ENG-PUDSP22005-R2-PDR redlines.pdf Markup Summary

Subject: Stormwater Comments Color
Page Index: 1
Date: 10/23/2022 11:02:03 AM
Author: dotprete
Color: ■
Layer:
Space:
Page Label: 1

Subject: PCD Comment Legend
Page Index: 1
Date: 10/25/2022 9:54:36 AM
Author: dsdrice
Color: ■
Layer:
Space:
Page Label: 1

DR: SLP CH: RDL  
P.M: RDL  
JOB: 21002568  
SHEET NO. 1  
DR-02

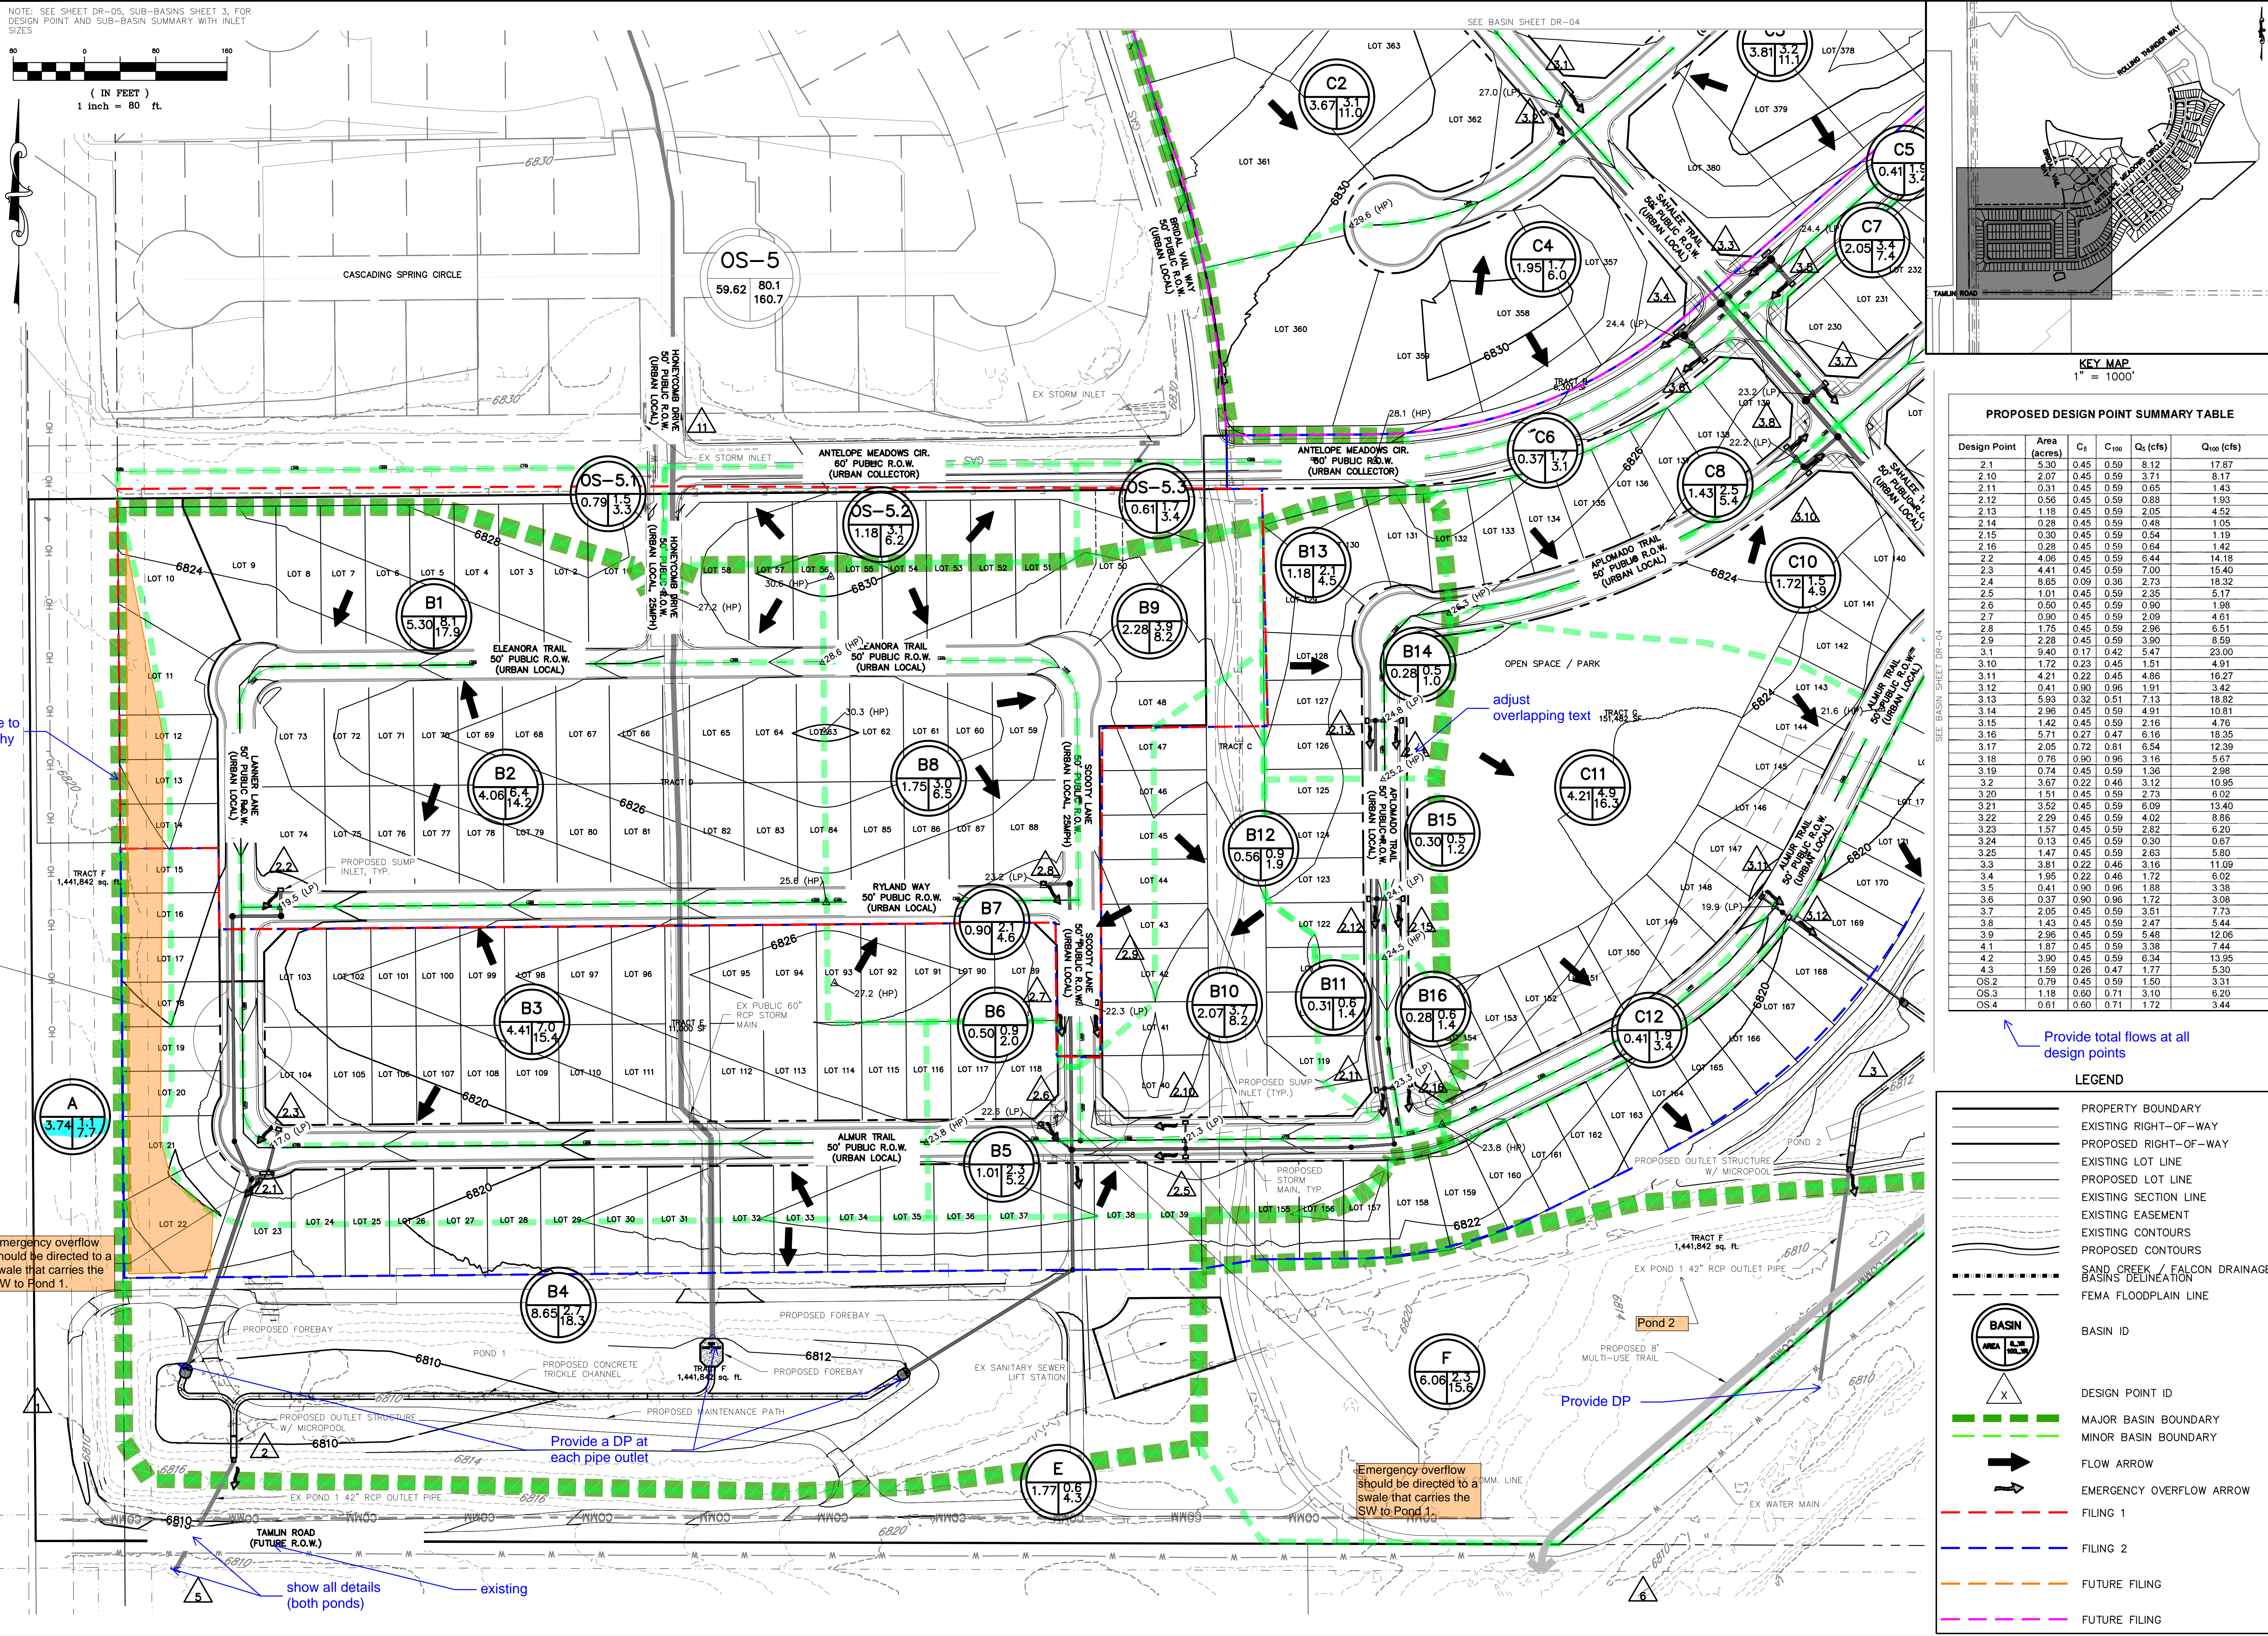
Show Tamlin Road ROW on all plans

Provide total flows at DPs also

Is there an easement on the other property?

label side slopes

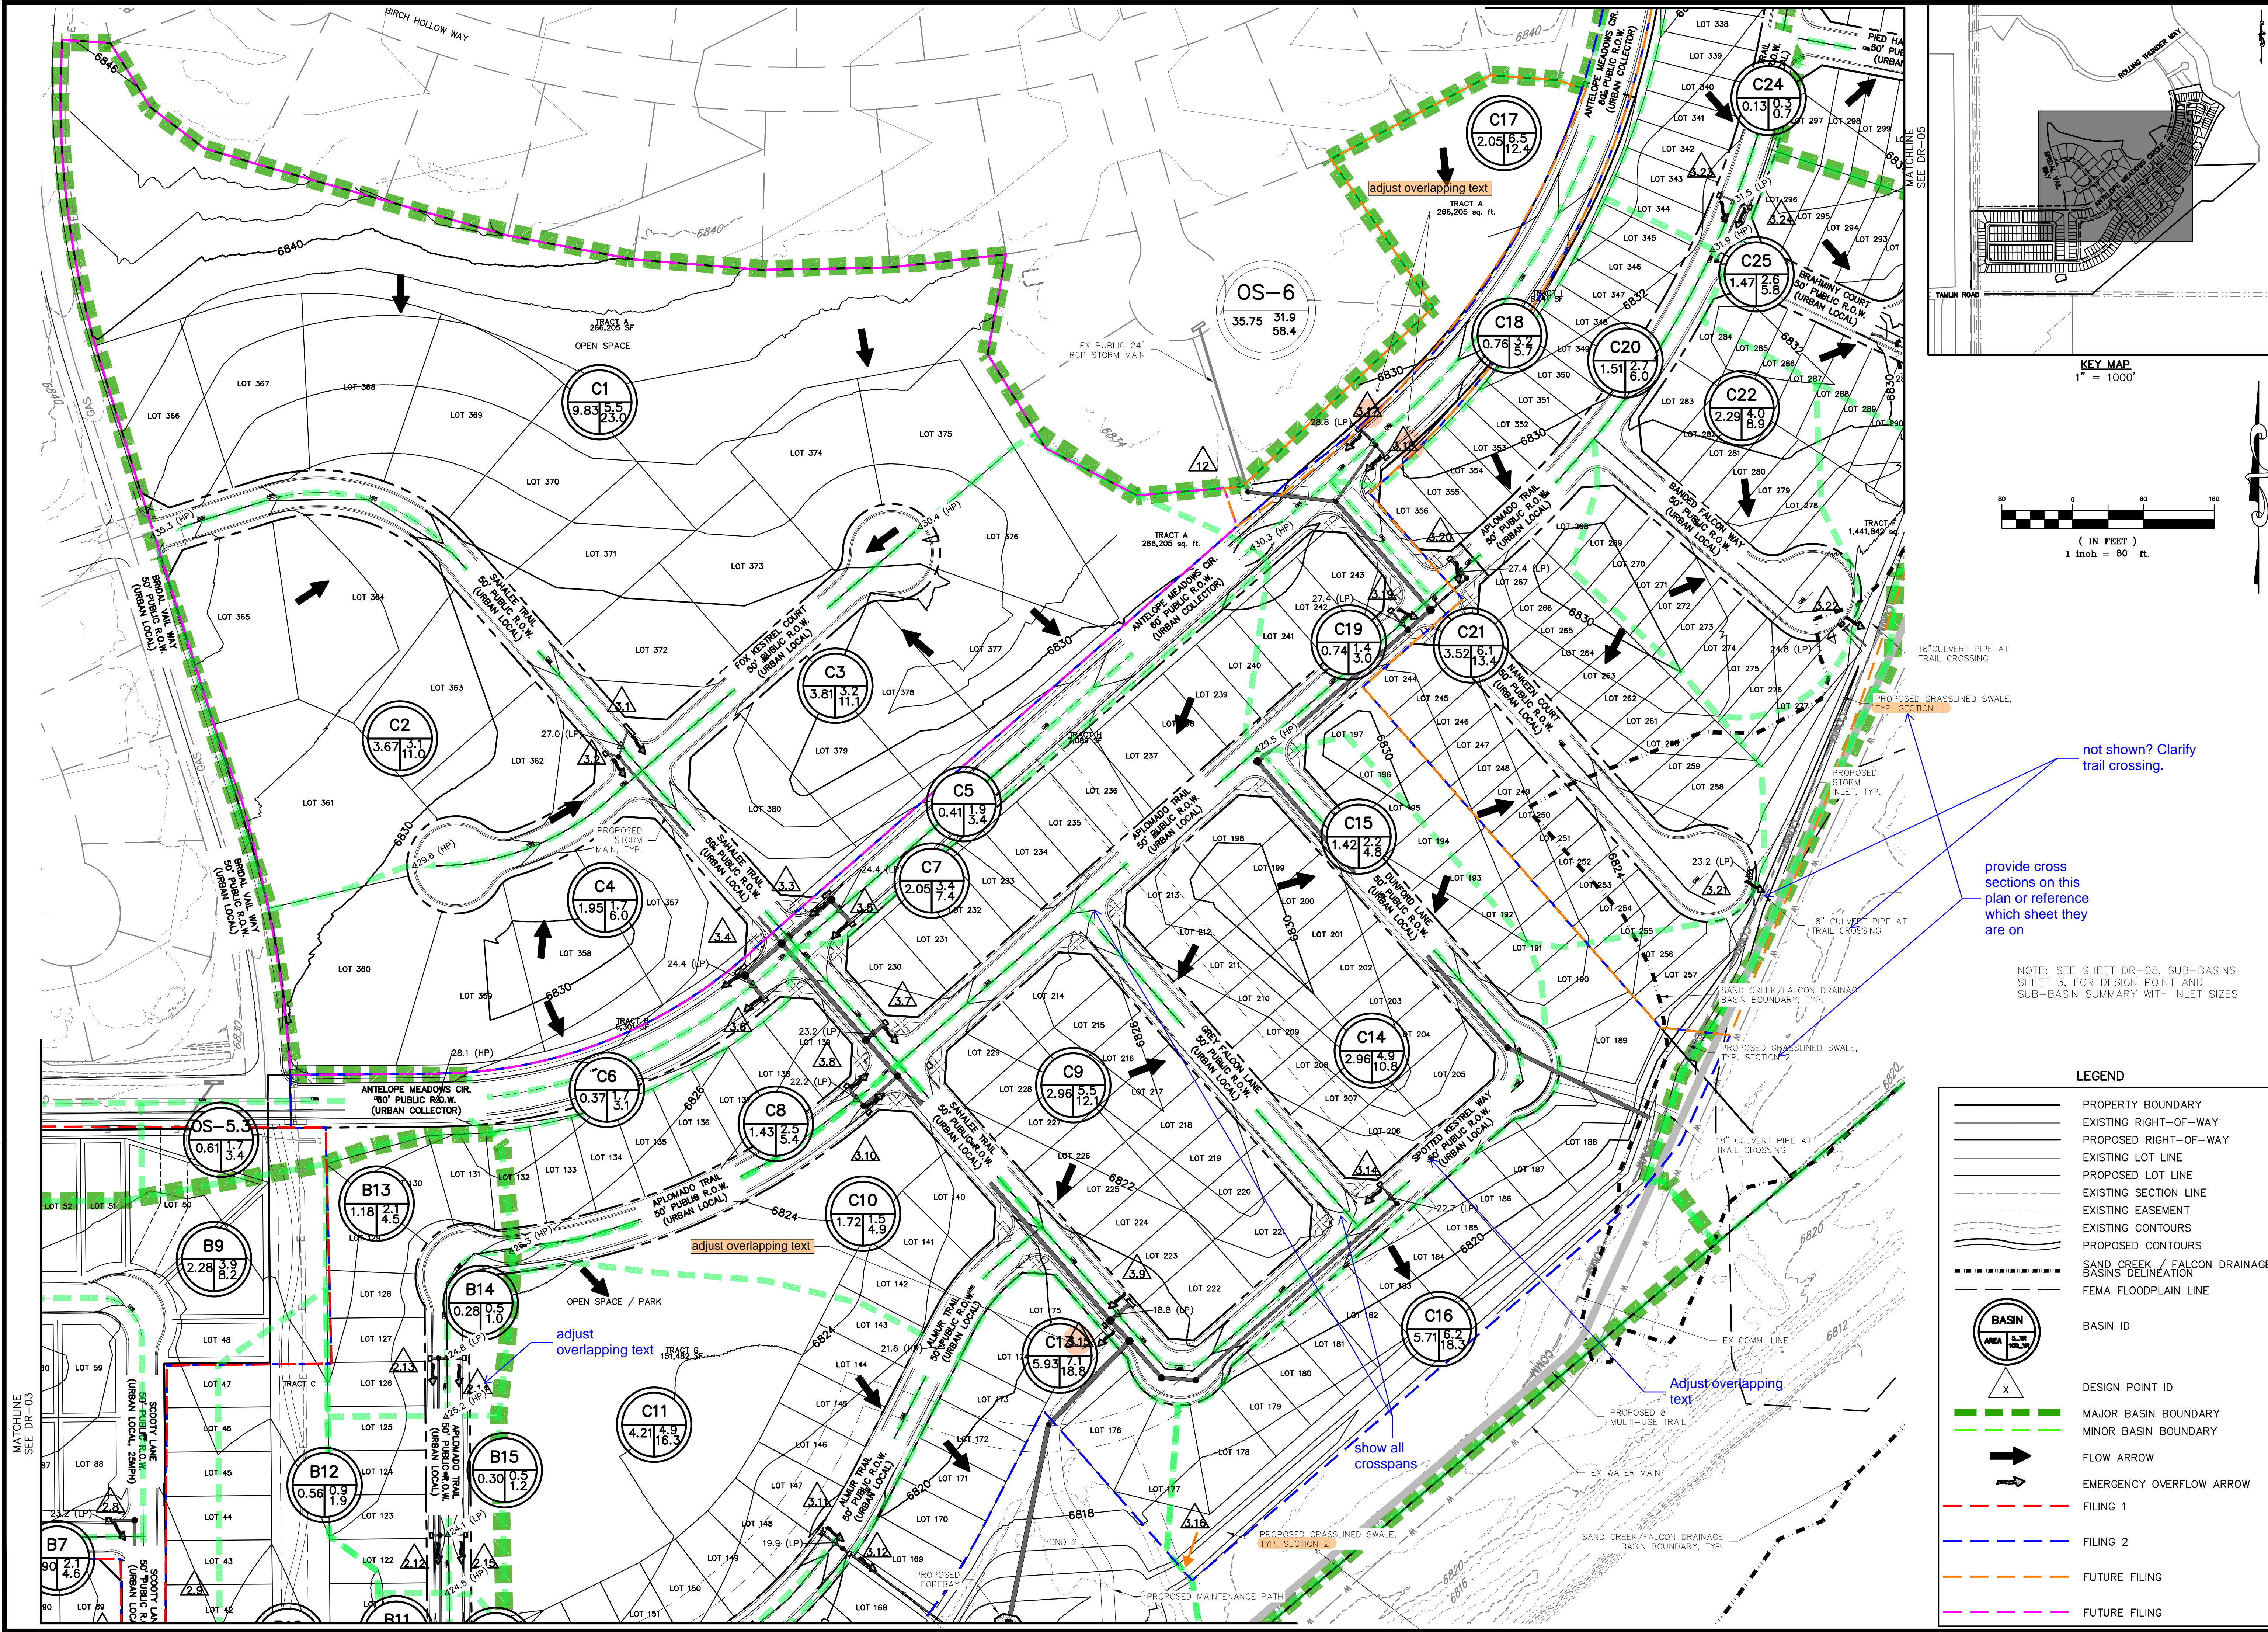
are these back lots part of Basin A or Basin B4?
 adjust basin lines accordingly.

Emergency overflow should be directed to a swale that carries the SW to Pond 1.

Adjust basin line to match topography

Provide a DP at each pipe outlet

show all details (both ponds)

Provide total flows at all design points

Provide DP

adjust overlapping text
